Application Reference: 2026/0305

Site Address: 19 Carr Lane, Pilley, Barnsley, S75 3BE

Proposal: Erection of single storey side and rear wrap-around extension and re-rendering of original dwelling and proposed extension.

Project	Extensions & Alterations
Client	Mr & Mrs Chris Whitton
Title	Elevations as Proposed
Address	19 Carr Lane, Tankersley, Barnsley, S75 3BE
Drawn By	GGG
Scale	1:100 @ A3 Date Apr 26
Drawing No	530-04 Rev

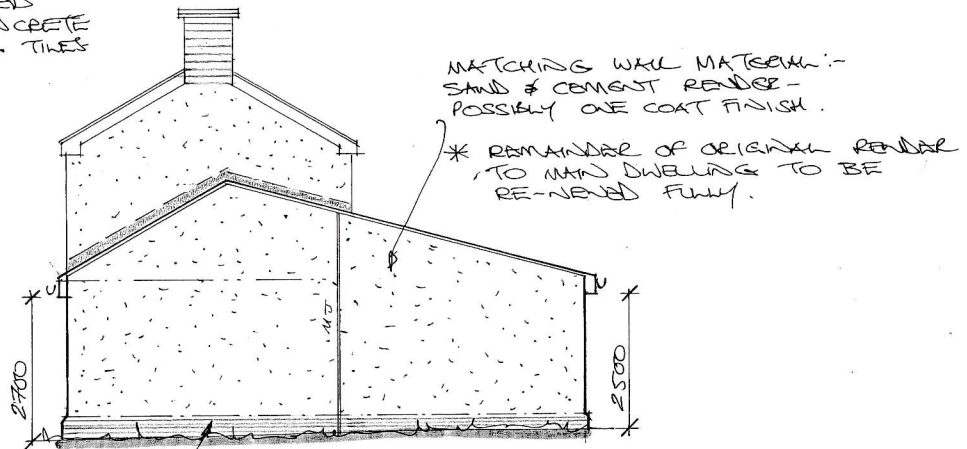
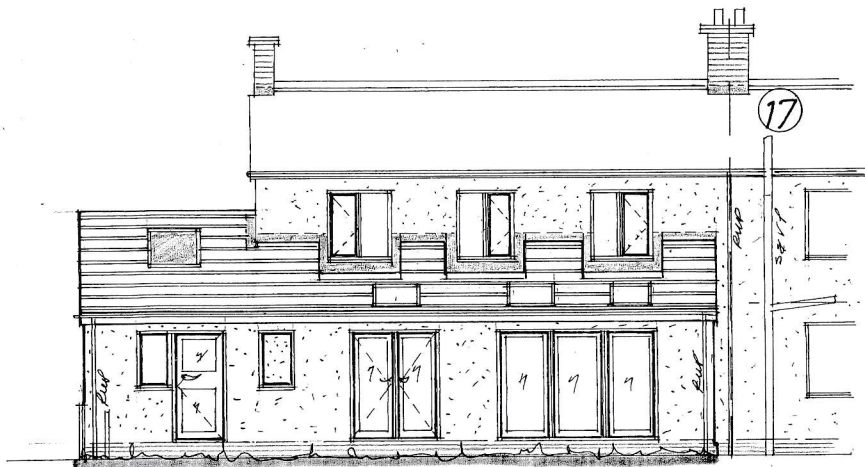
The proposed side extension provides an acceptable sideways projection at less than two thirds the width of the dwelling. The use of a pitched roof form allows the proposal to remain

in keeping with the character of the dwelling and street scene. Glazing has been detailed centrally to the extension along with a rooflight providing similar fenestration to the existing dwelling. The side of the dwelling is currently home to a detached garage which is considered to be of poor quality. The proposal would therefore provide an improvement to the site and be more in keeping with the street scene.

The proposed rear extension provides a significant rearward projection, narrowly exceeding the 4 metres outlined within the House Extensions SPD. The rearward projection of the extension can be considered modest in the context of the property and the size of the rear garden. A modest eaves height has been proposed and the lean to roof is required in order to incorporate the rear roof pitch into the side extension roof pitch. Rear glazing has been proposed which is in keeping with the existing dwellings glazing.

Matching render has been proposed. Given the street scene fails to provide any dominant materials, the use of render is not considered to be controversial and is in keeping with the existing character of the dwelling.

The proposed side extension would be to the northeast of 21 Carr Lane and would therefore not be impactful on neighbouring loss of light. The side extension would replace the existing garage to the side of the dwelling. The impact of the side extension would therefore not be significantly more impactful than the existing garage, albeit there is a height increase. Due to the topography of the street, the neighbouring dwelling is also elevated higher than the site which would reduce the impact further. No side elevation windows have been proposed, preventing any opportunity for direct overlooking.

The proposed rear extension would be located to the southwest of the adjoining neighbour. Any overshadowing from the proposal would therefore be restricted to late evenings. The proposal is acknowledged larger than what could be built under permitted development but is only marginally larger than the recommended projection in the SPD. Furthermore, an extension with a similar projection (albeit not wrap around) could be applied under the larger homes' extension procedure. The impacts of the proposal are therefore likely to be limited and do not warrant refusal or amendment. The site provides significant boundary treatment, screening the majority of the proposal, and preventing the proposal from having a detrimental impact. The proposed rear elevation windows would not be likely to cause significant overlooking due to the boundary treatment.

Amendments were requested to reduce the rearward projection down to 4 metres, however given the proposal would exceed the 4-metre rearward projection by 0.3 metres, the current proposal was on balance considered acceptable.
